DELEGATED DECISION TO DETERMINE PLANNING APPLICATIONS

Reference No: 2021/62/92416/W
Site Address: 57, The Cutting, Brockholes, Holmfirth, HD9 7HL
Description: Erection of single storey side extension
Recommending Officer: Laura Yeadon

DECISION - CONDITIONAL FULL PERMISSION

Officer Report

21\_892 101

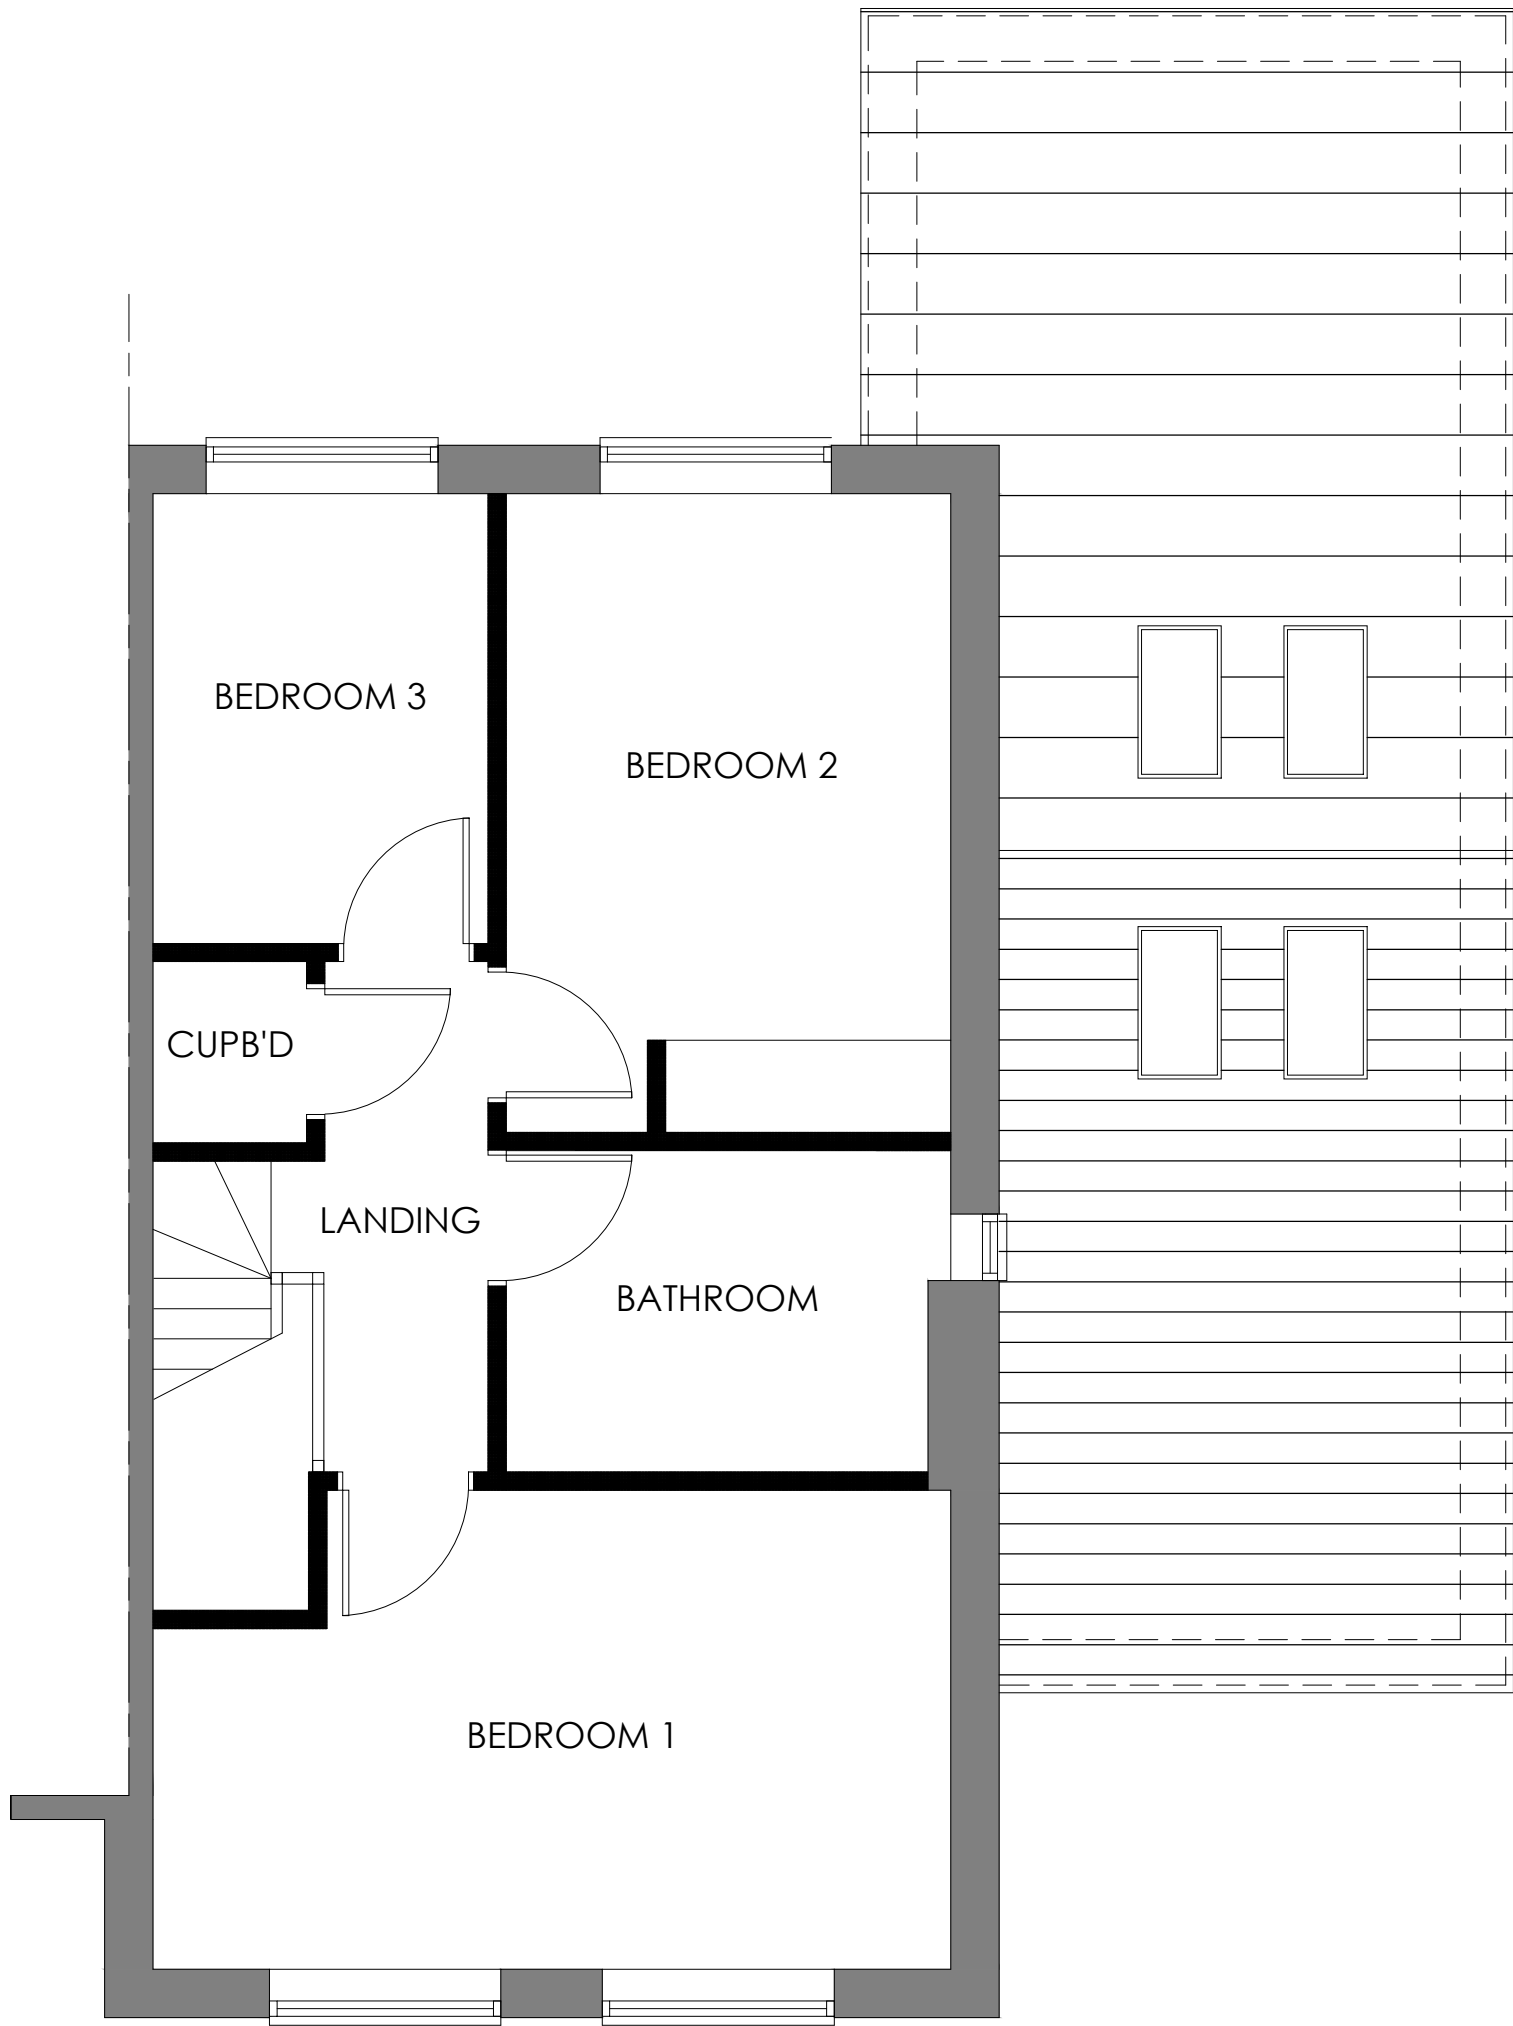
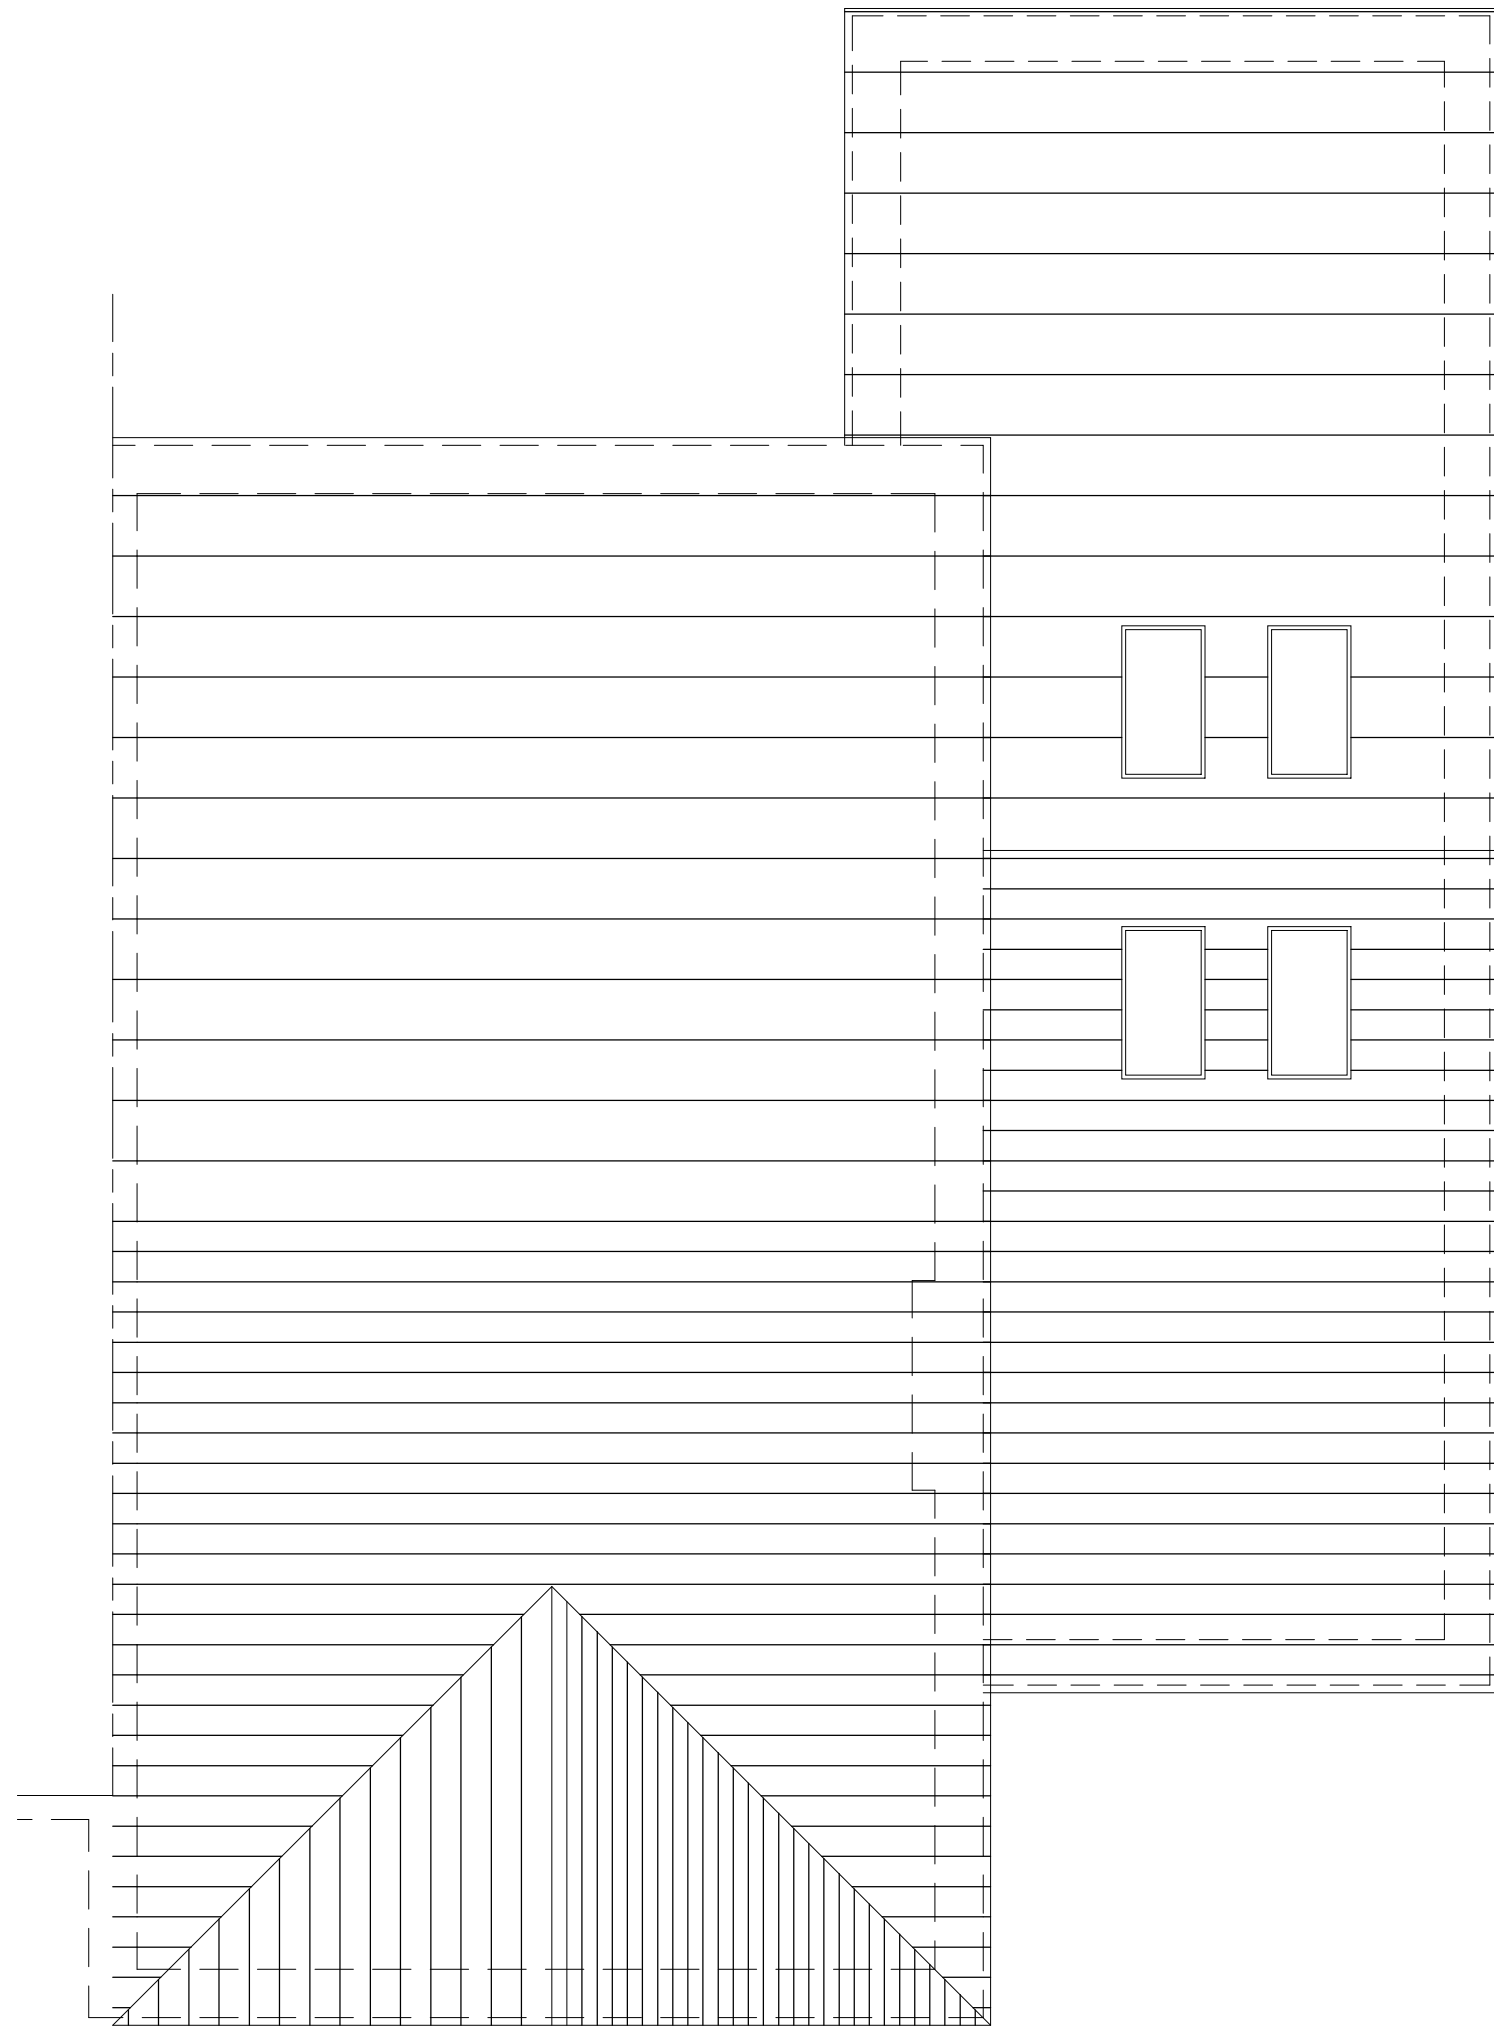
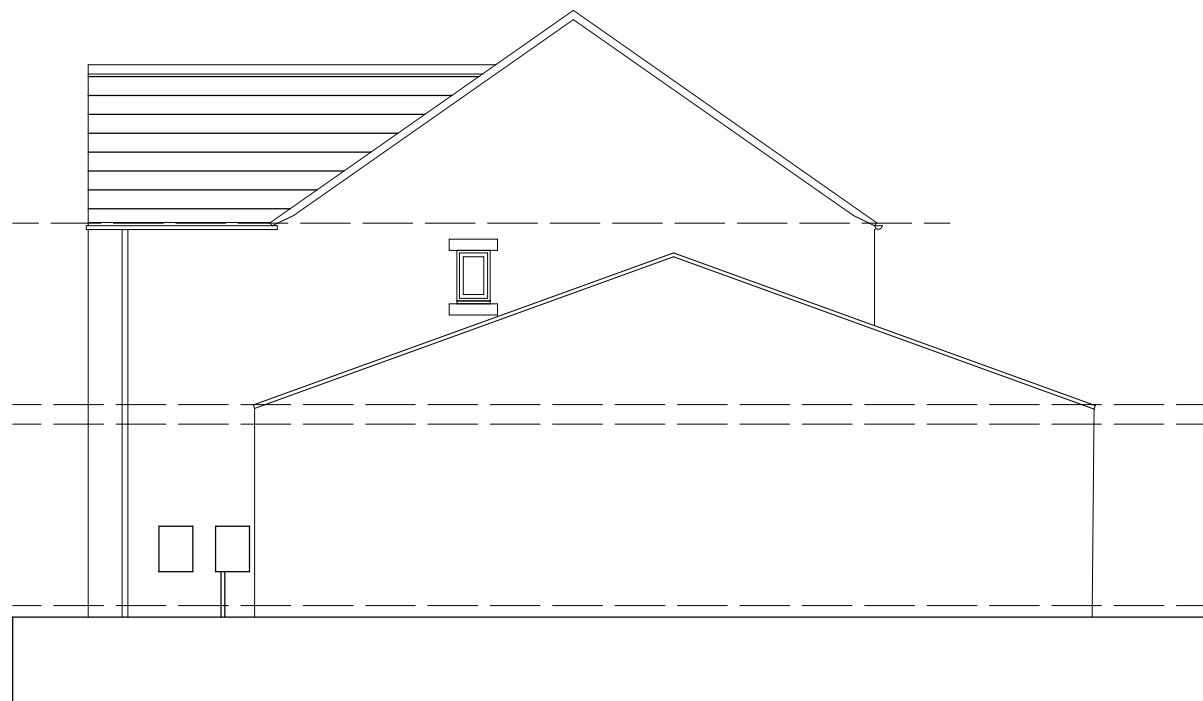
In terms of visual amenity, the proposed extension would be located on the side elevation of the property and would sit on the existing driveway. The proposed ridge of the extension would be below the height of the eaves of the property and therefore would appear subservient when viewed against the host property. The construction materials would match and a condition can be attached to ensure this in the interest of visual amenity. The roof line would be pitched and openings are proposed within the front elevation, front and rear elevation roof slopes and within the side elevation of the projecting rear element. No openings are proposed within the side elevation facing No. 59.

Overlooking – in terms of overlooking, openings are proposed windows within the front and side elevations of the extension. Given that these would be set back from the existing front elevation openings, the separation distance

between the application site and the properties on Oakes Avenue would not be reduced. The openings within the rear section of the extension would face the garden area of the property and therefore minimal concerns are raised. It is not anticipated that there would be significant harm from the proposed roof lights.

Drawing Scale_	Drawn By_	Checked By_
1:500 1.1250	JaL	JaL
Paper Size_	Drawn Date_	Checked Date_
A3	30/04/21	03/06/21
Drawing Number_	21_892 103 A

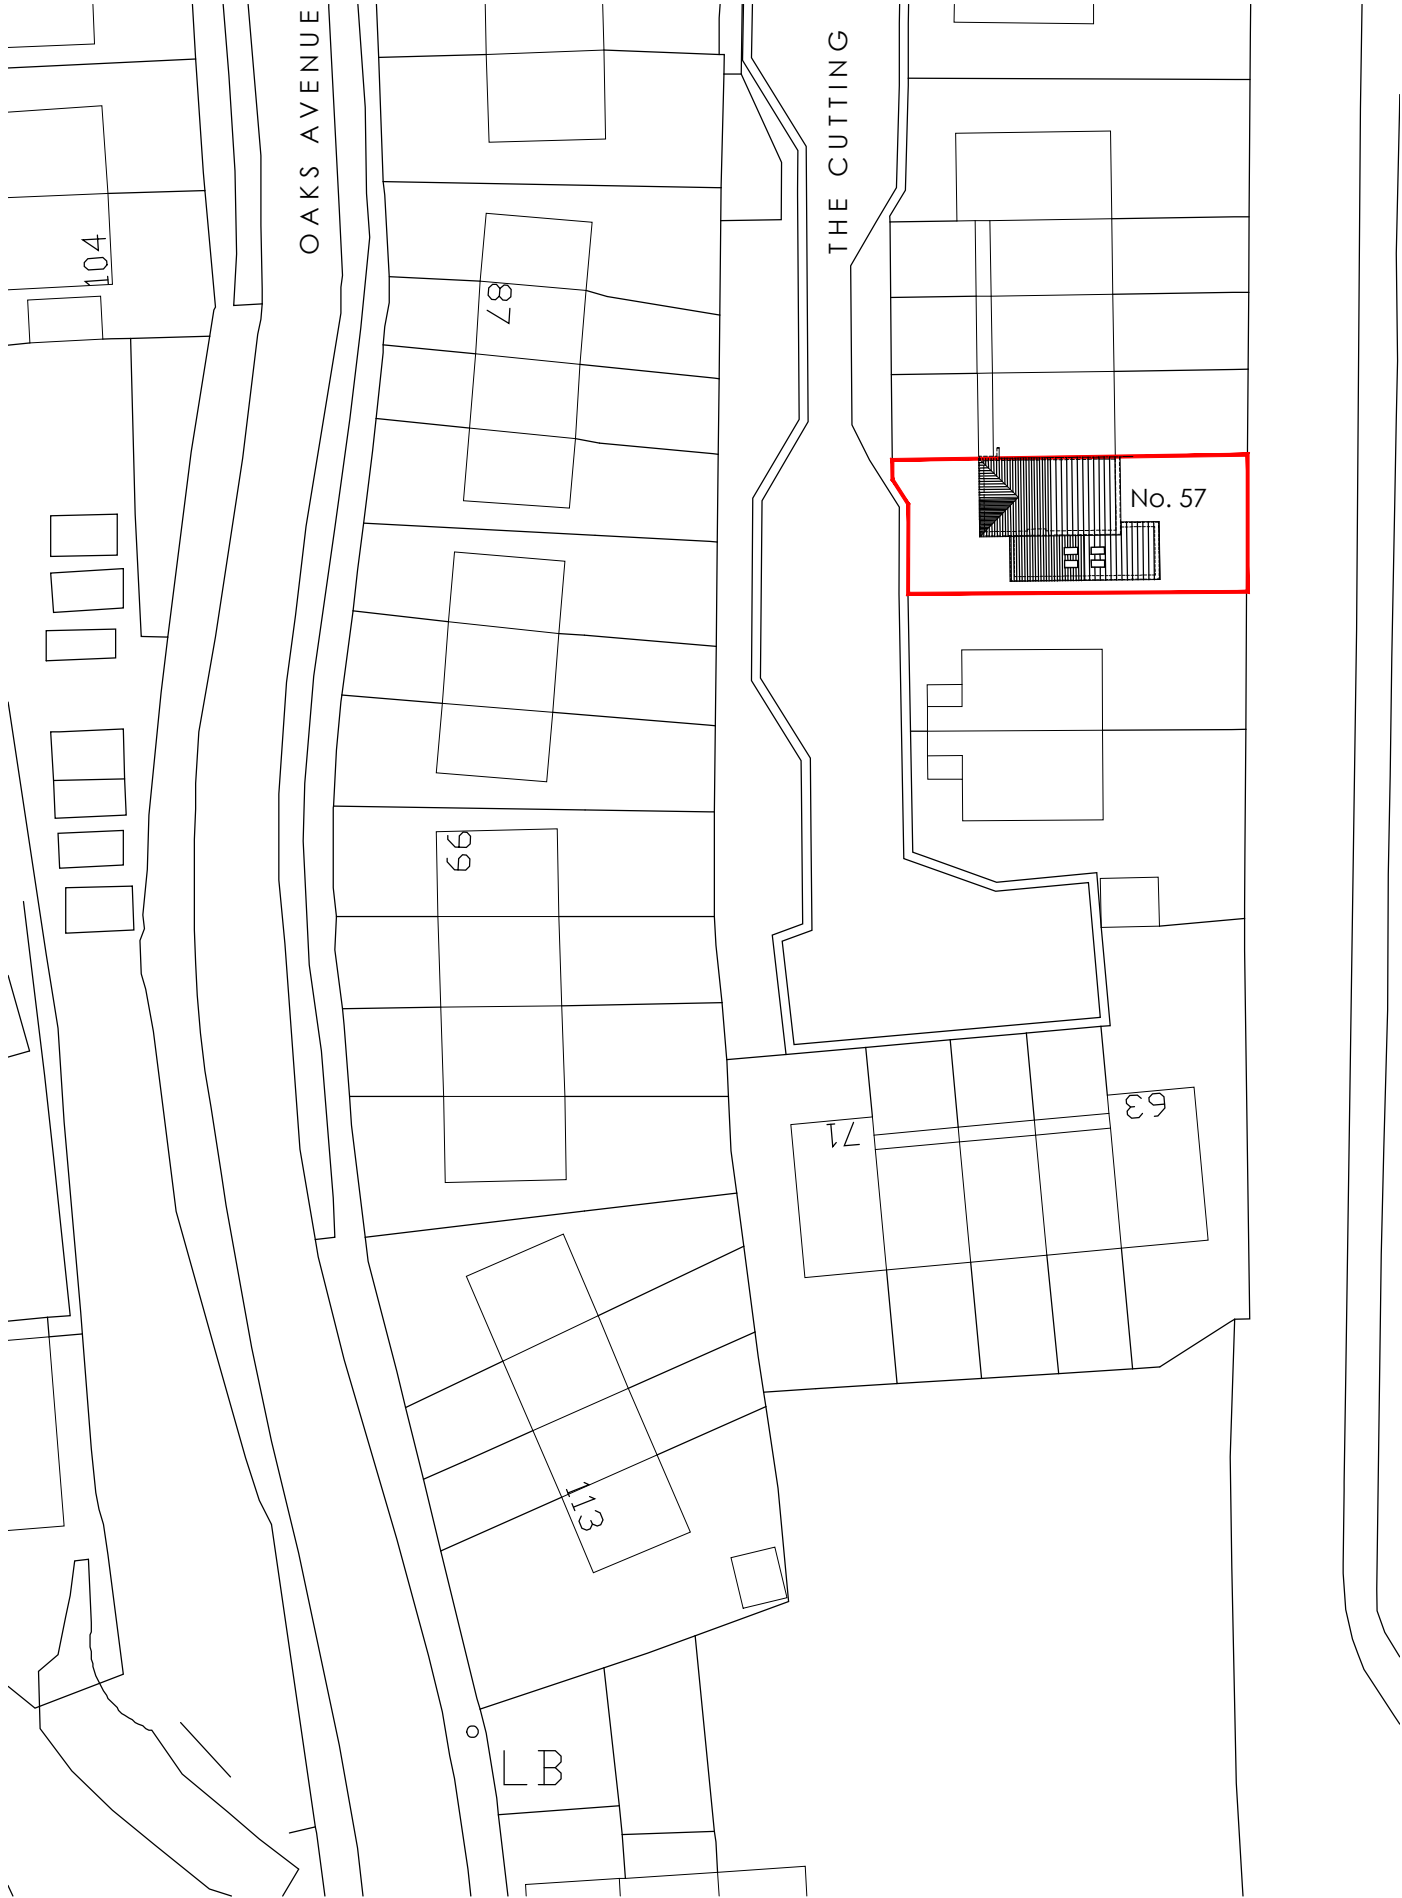
In terms of the impact on highway safety, the proposed extension would be located on the driveway of the property. A proposed site plan has been submitted with the application which demonstrates that 1 no. vehicle can be sited to the front of the property and a site visit confirmed that there are parking bays along the roadside within the ownership of the properties along The Cutting.
